WEST SUSSEX COUNTY COUNCIL CONSULTATION

TO:	Arun District Council FAO: Raymond Cole
FROM:	Stephen Gee WSCC - Highways Authority
DATE:	17 April 2020
LOCATION:	Land at Ford Airfield Ford, West Sussex
SUBJECT:	F/4/20/OUT Outline planning application (with all matters reserved except for access) for the development of up to 1,500 dwellings (Use Class C3), 60-bed care home (Use Class C2), up to 9,000 sqm of employment floorspace (Use Classes B1), local centre of up to 2,350 sqm including up to 900 sqm retail / commercial (Use Classes A1-A5) and 1,450 sqm community / leisure floorspace (Use Classes D1-D2), land for a two-form entry primary school (Use Class D1), public open space, allotments, new sports pitches and associated facilities, drainage, parking and associated access, infrastructure, landscape, ancillary and site preparation works, including demolition of existing buildings and part removal of existing runway hardstanding. This application affects a Public Right of Way. This application is the subject of an Environmental Statement. This application falls within CIL Zone 1 - Zero Rated.

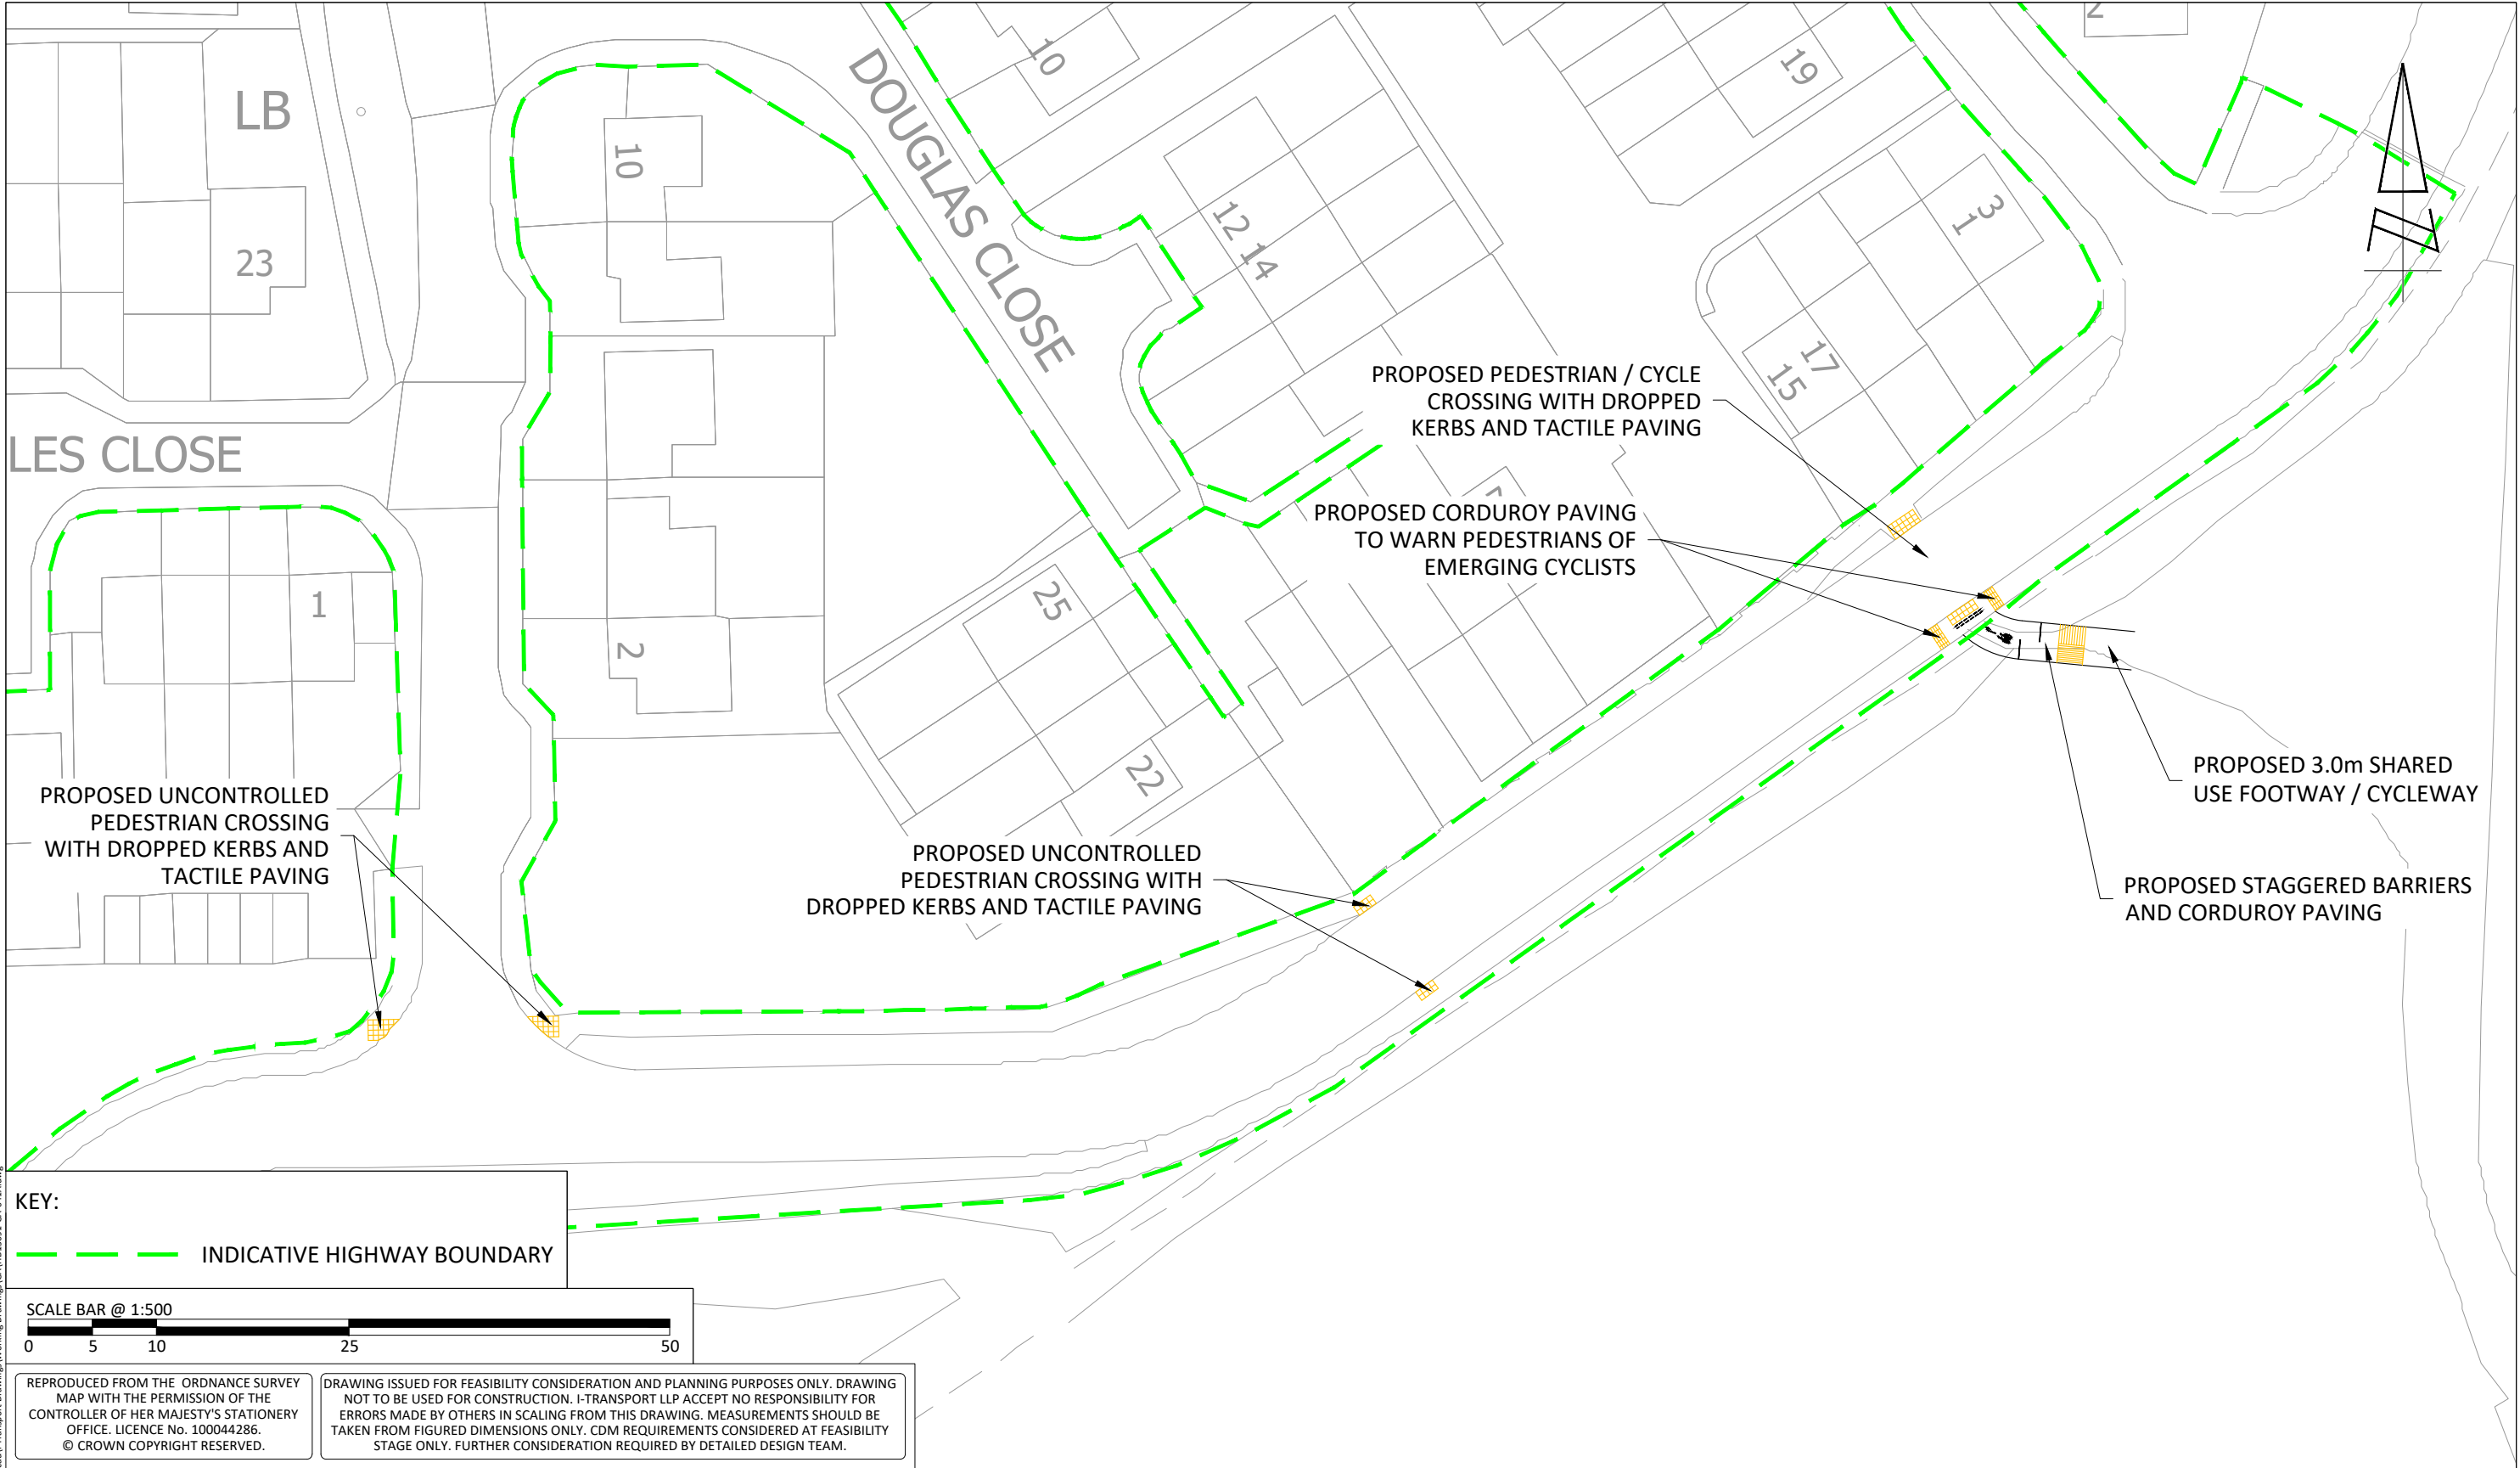
A pedestrian and cycle link into Rollaston Park is shown in drawing number ITB13091-GA-041; no cycle facilities are provided along Rollaston Park and as such cyclists would be required to re-join the carriageway. Further improvements are proposed towards Yapton, which includes:

Given that the link would be the primary connection between the development and Yapton then further consideration should be provided to the extent of cycle facilities provided.
